Appeal Decision

Appeal Ref: APP/R5510/D/19/3225701

131 Shakespeare Avenue, Hayes, UB4 0BQ

- The appeal is made under section 78 of the Town and Country Planning Act 1990 against a refusal to grant planning permission.
 - The appeal is made by Mr Kevin Fernando against the decision of the Council of the London Borough of Hillingdon.
 - The application Ref 23231/APP/2019/238, dated 22 January 2019, was refused by notice dated 18 March 2019.
 - The development proposed is described as "Demolishing two existing sheds in the back garden and erecting a single storey outbuilding with the maximum height of 2.5 meters".
-

PLAN, ELEVATIONS,
LOCATION PLAN AND
EXISTING AND PORPOSED
BLOCK PLAN

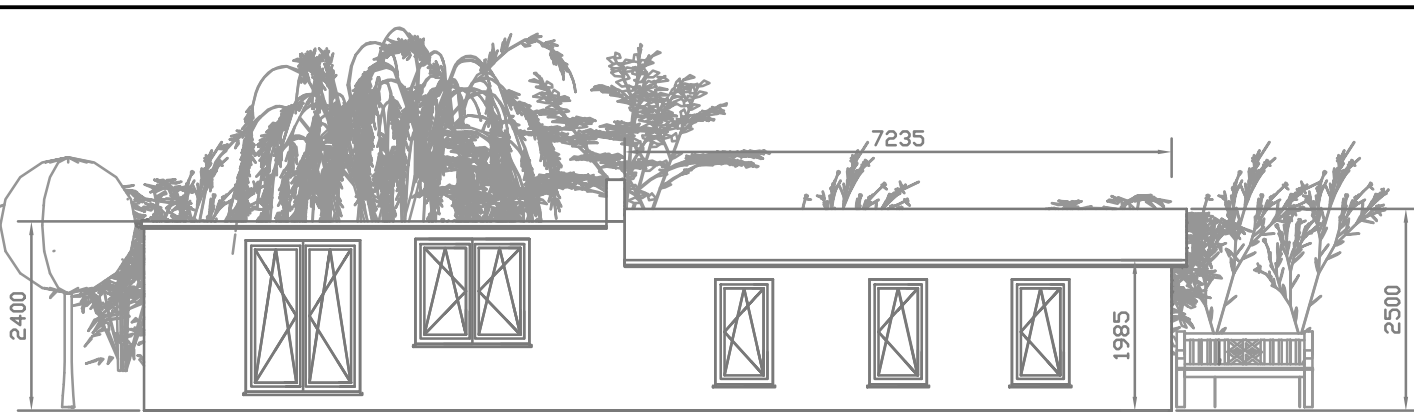
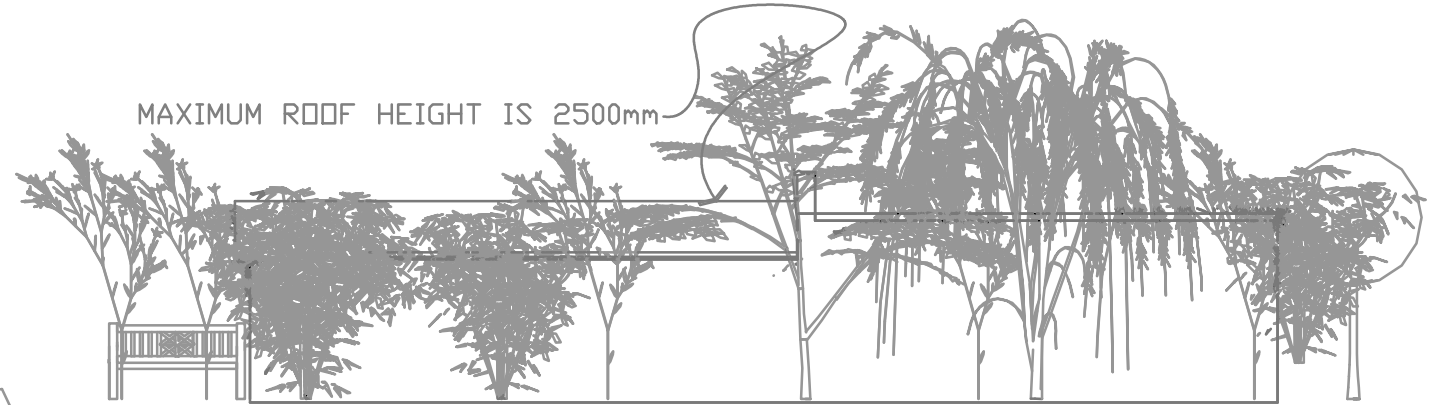
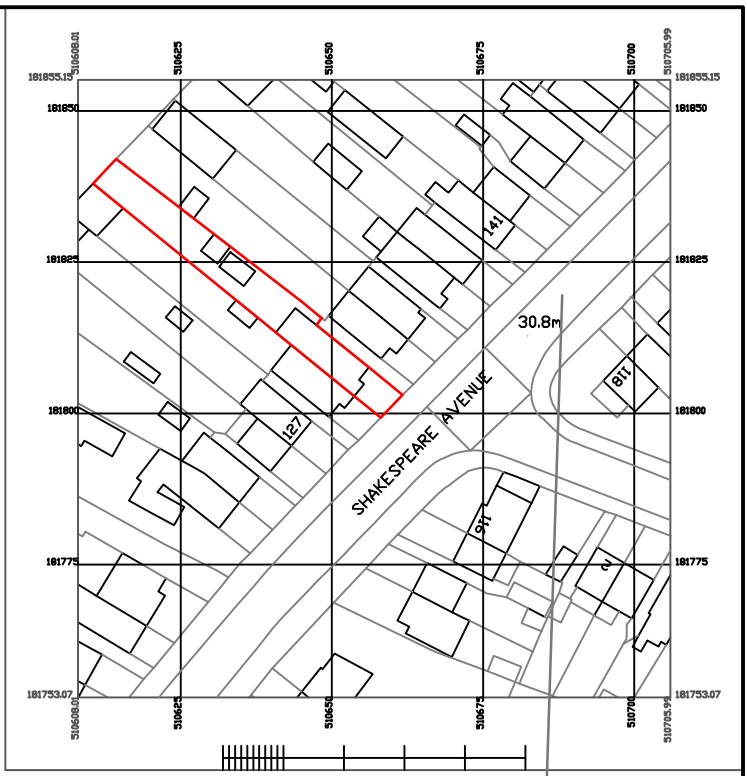
7. I also recognise that the proposal would be sited in close proximity to the site boundaries and approximate 1.8 metre high fencing. The pitched roof and some brickwork would therefore be visible from neighbouring dwellings and their rear garden areas. However, this would not be of a dissimilar size and scale as some of the other outbuildings that are located in neighbouring rear garden areas.

9. It is acknowledged that windows within the south west side elevation of the proposal would face the rear garden area of 129 Shakespeare Avenue. Nonetheless, the rear garden area of the appeal dwelling is enclosed by approximate 1.8 metre high boundary fencing and I consider that this would not only prevent a substantial amount of overlooking and undue loss of privacy

occurring, but would act as an effective screen to views of most of the building. Whilst the proposal would be of a substantial length, the flat and shallow pitched roofs would help to reduce any sense of bulk and overall prominence. In light of these factors, and the considerable length of the garden plots, I do not consider that the proposal would appear overly intrusive or unacceptably overbearing from Nos 129 and 133 or their rear garden areas.
